From: Joanne Needham <joanne.needham@spab.org.uk>
Sent: 03 February 2021 12:18
To: Adrian Dowd; Planning
Subject: RE: 3/2020/0853 Lovely Hall, Salesbury - SPAB Response

Application ref: 3/2020/0853

Address: Lovely Hall. Lovely Hall Lane, Salesbury, Lancashire, BB1 9EQ

Proposal: Listed building consent - Re-roofing of existing building and installation of one en-suite shower room.

Existing Plans
First Floor and Roof

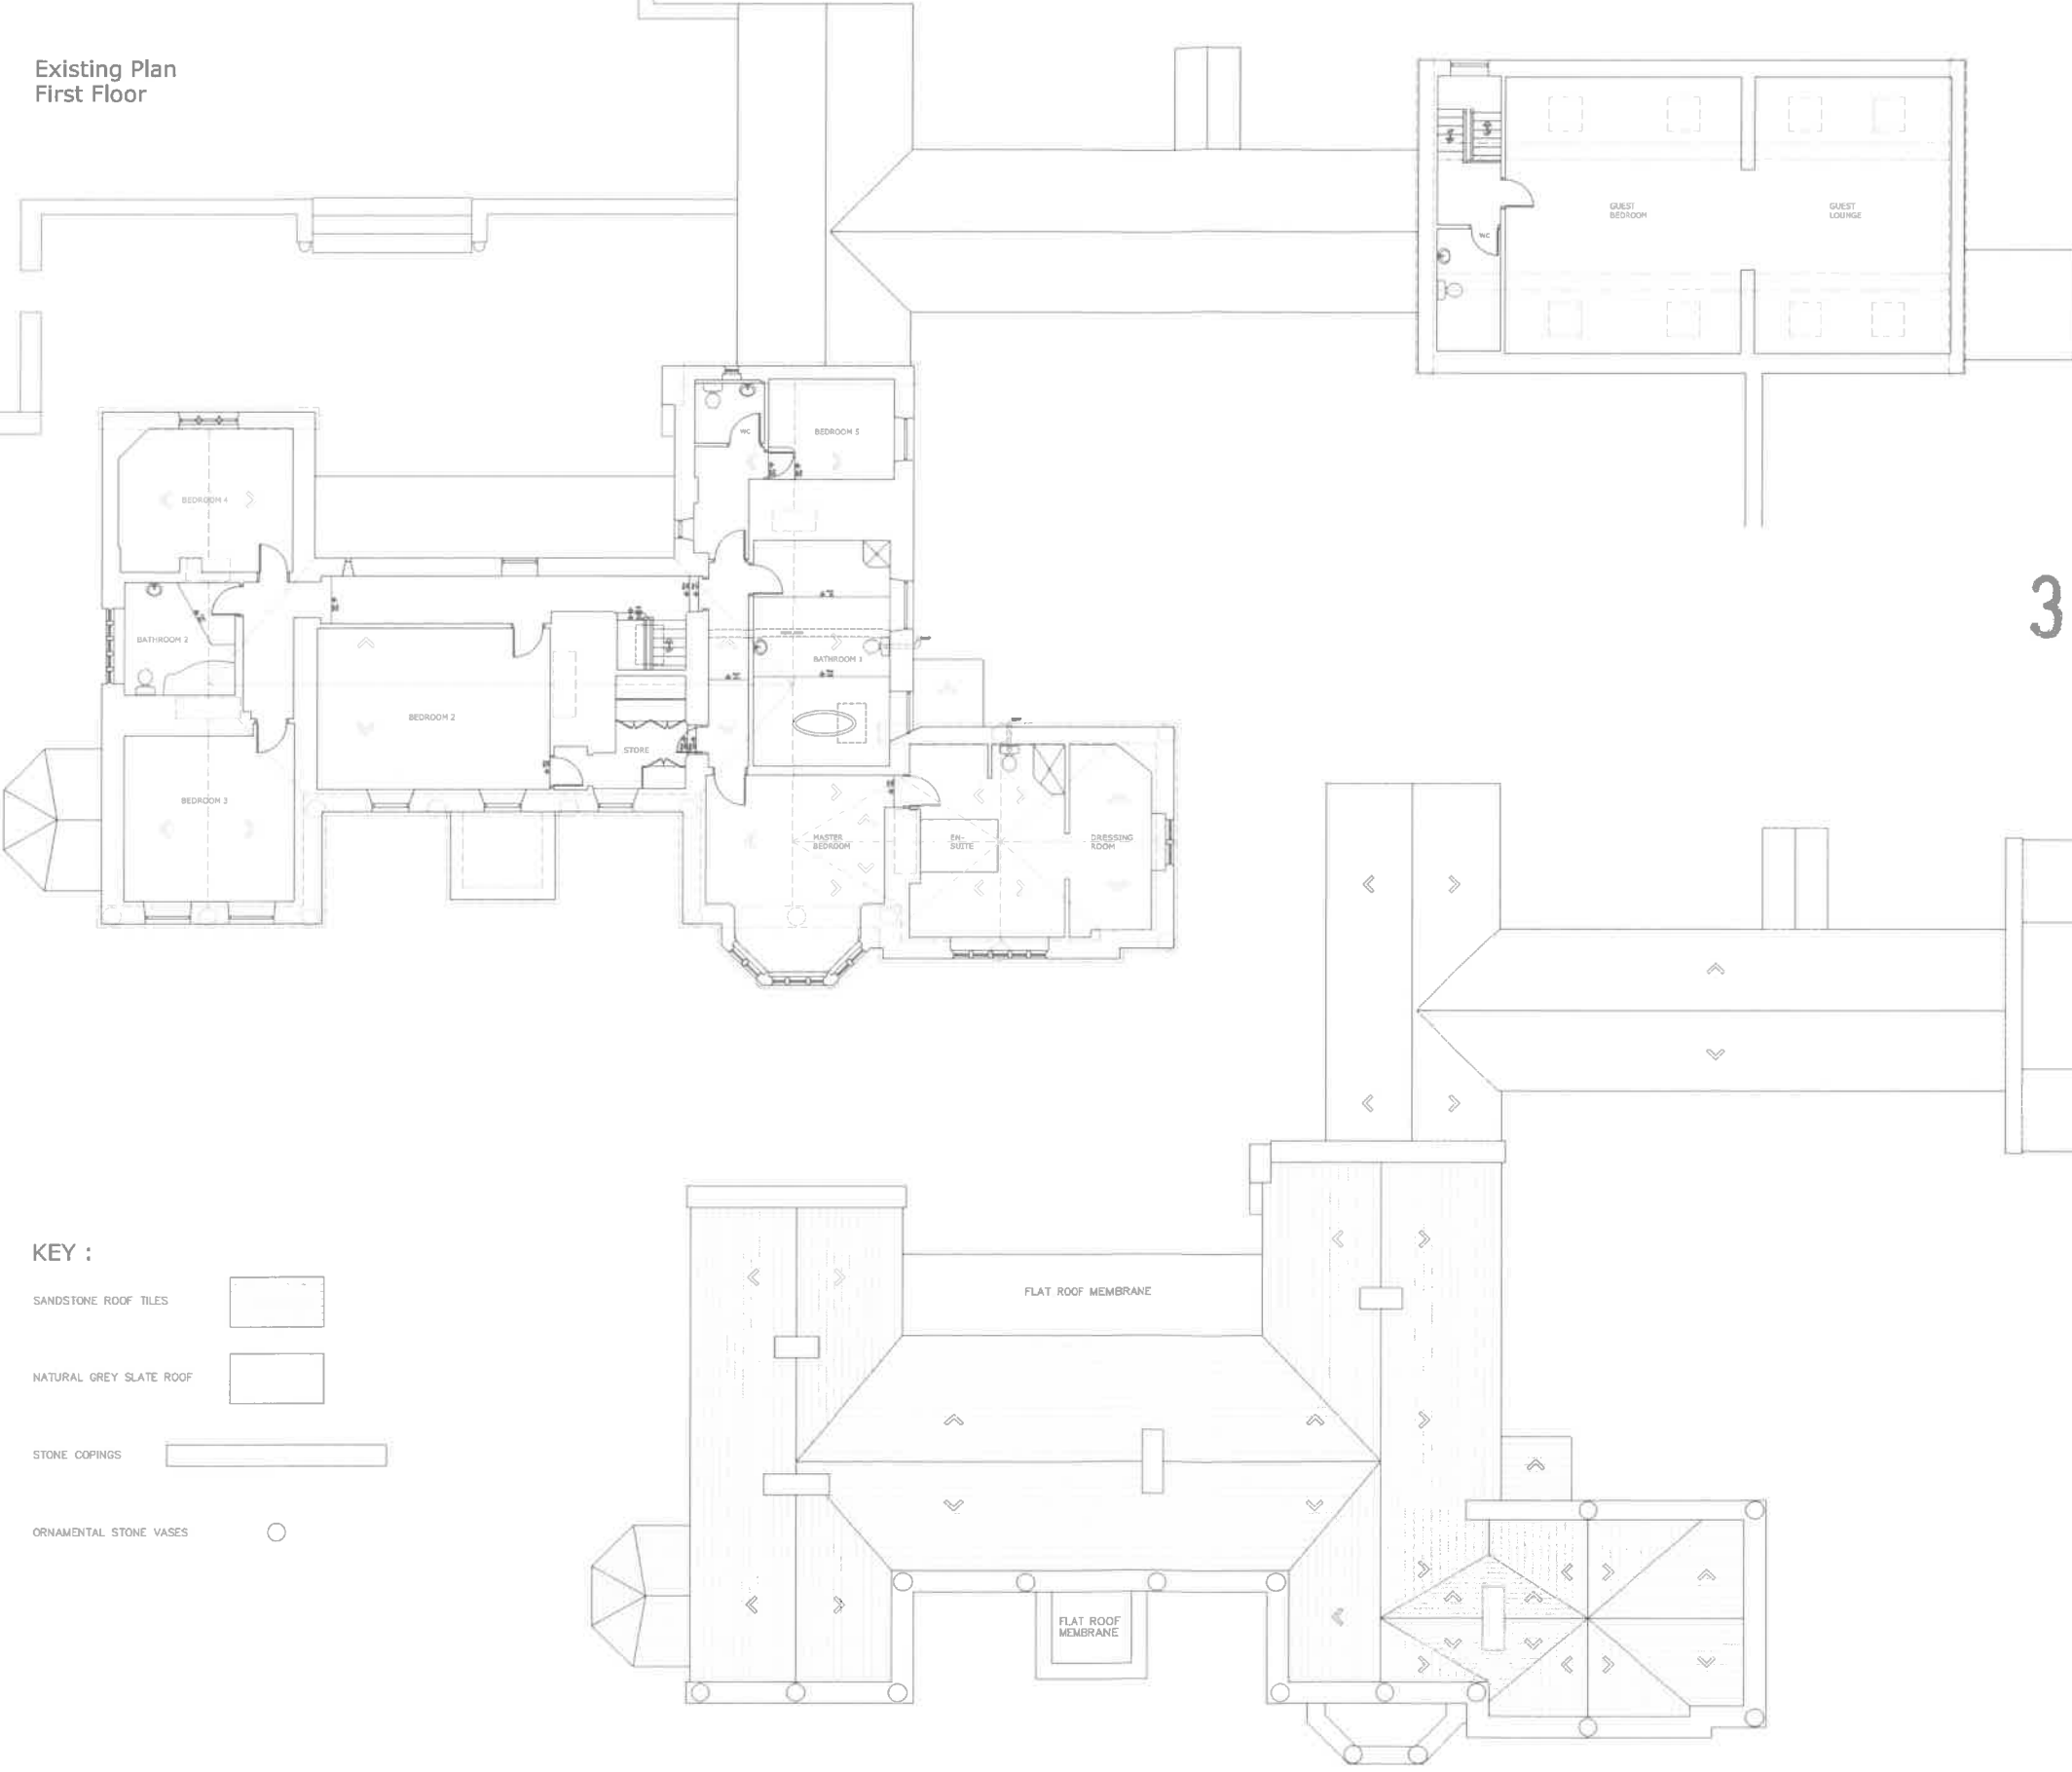
The Society notes the report of water ingress into the roof and therefore welcomes the proposition to undertake repairs. However, we advise that the current application does not contain sufficient information in respect of the existing roof, its make-up and significance, and details of the proposed works and their impact on it.

Proposed Plan
First Floor

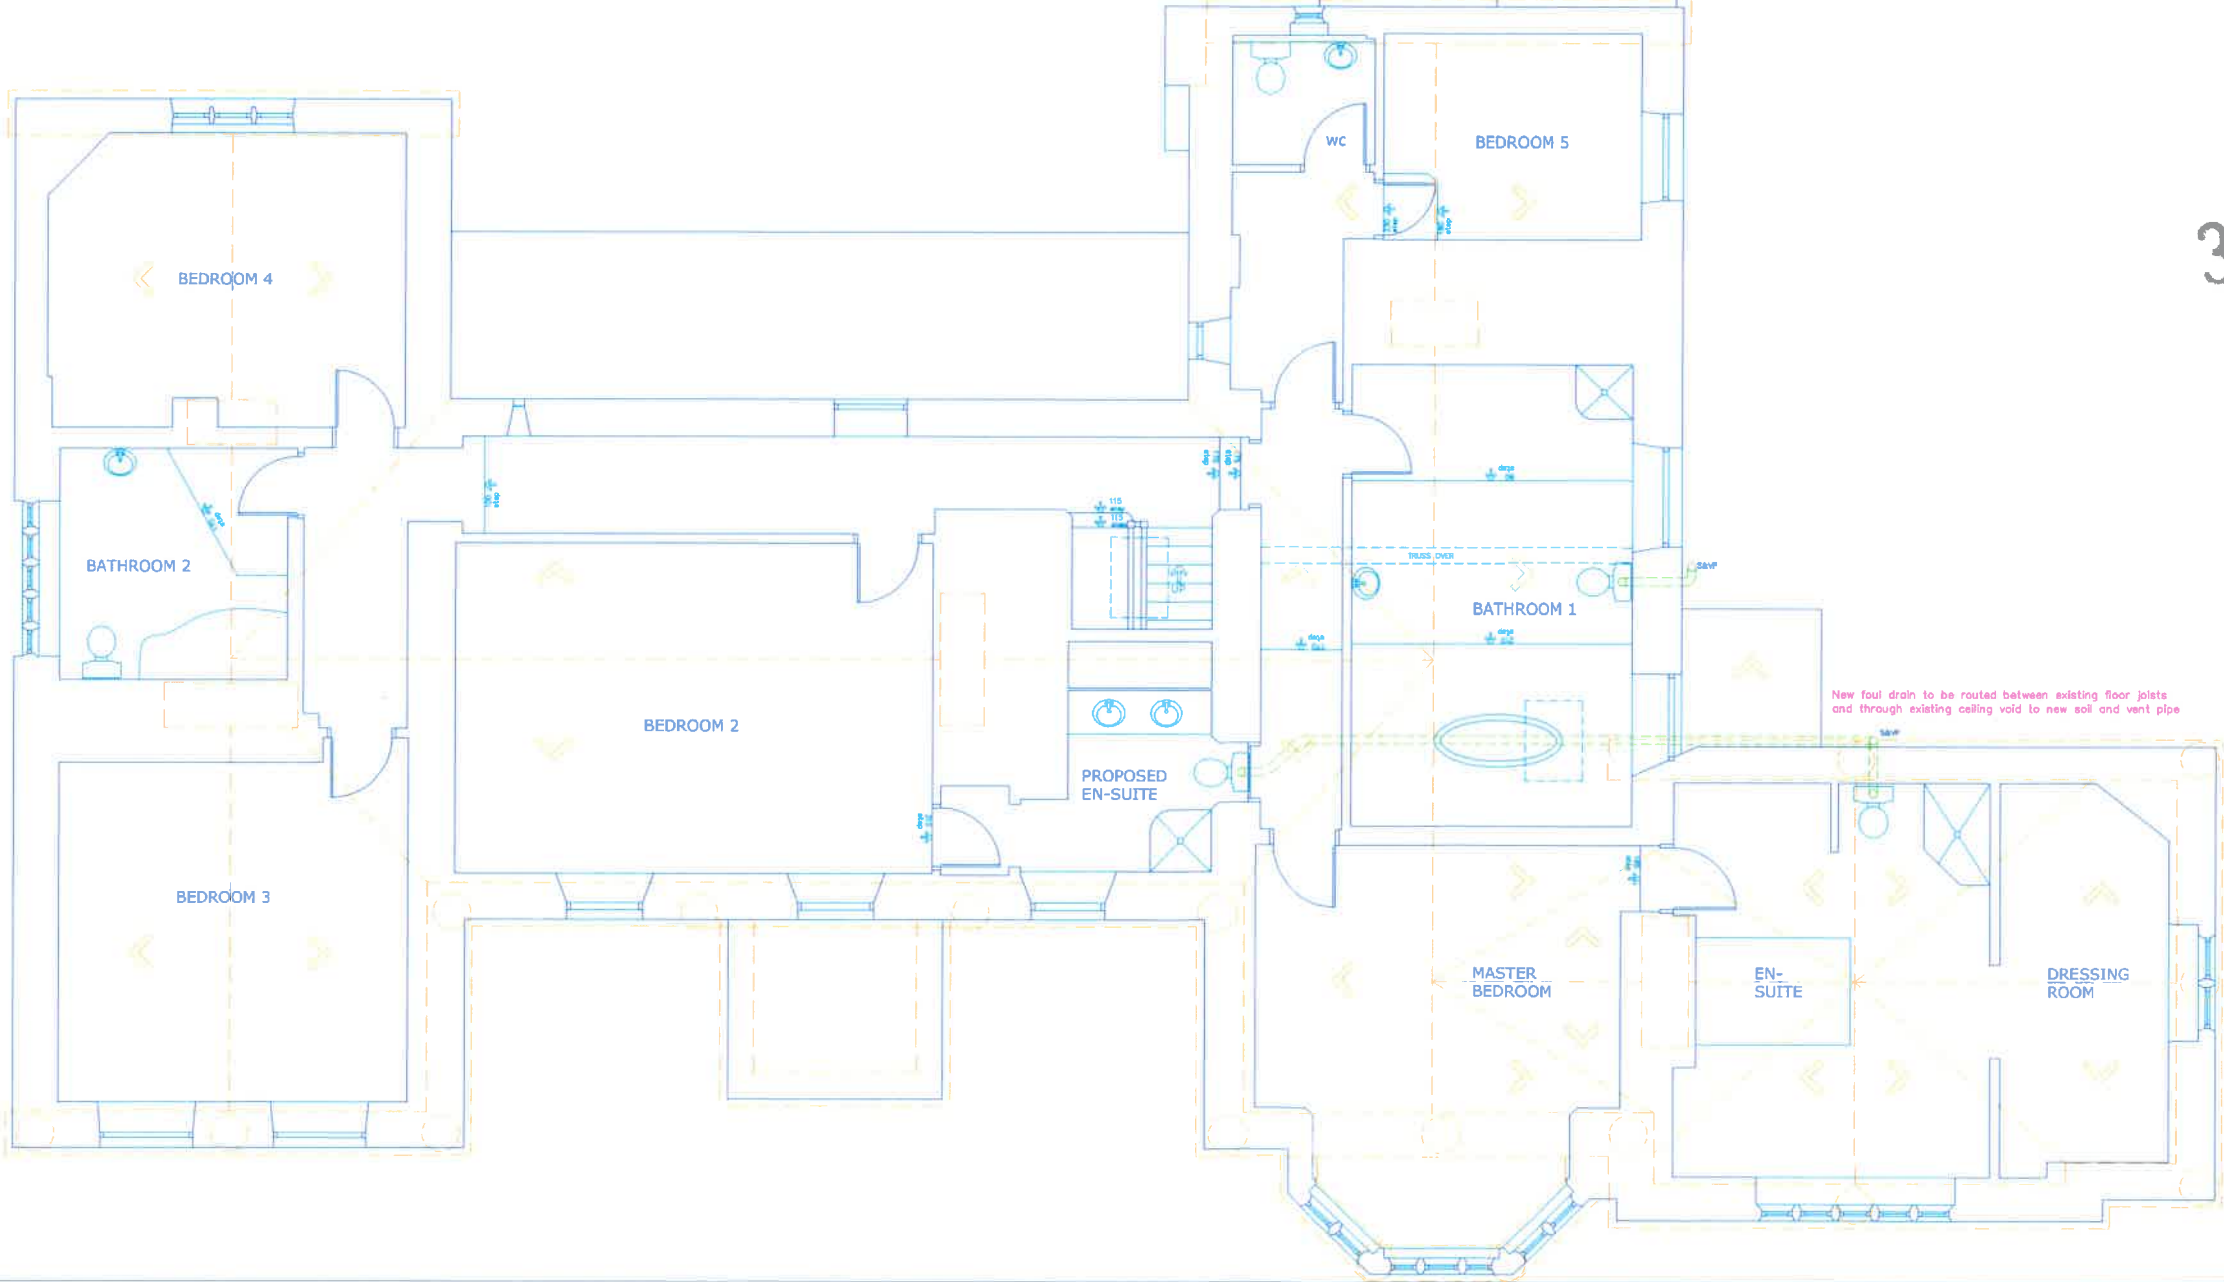
In respect of the proposed en-suite, the floor plans suggest that this use may be acceptable and possible with minimum harm to the building. However, as with the proposals for the roof, there is insufficient information to enable a full assessment of the impact of the proposals to be made. Details of the plumbing and drainage (and any loss/impact on historic fabric, and elevations) should be provided, together with details of what will happen to the existing door and steps to the store.
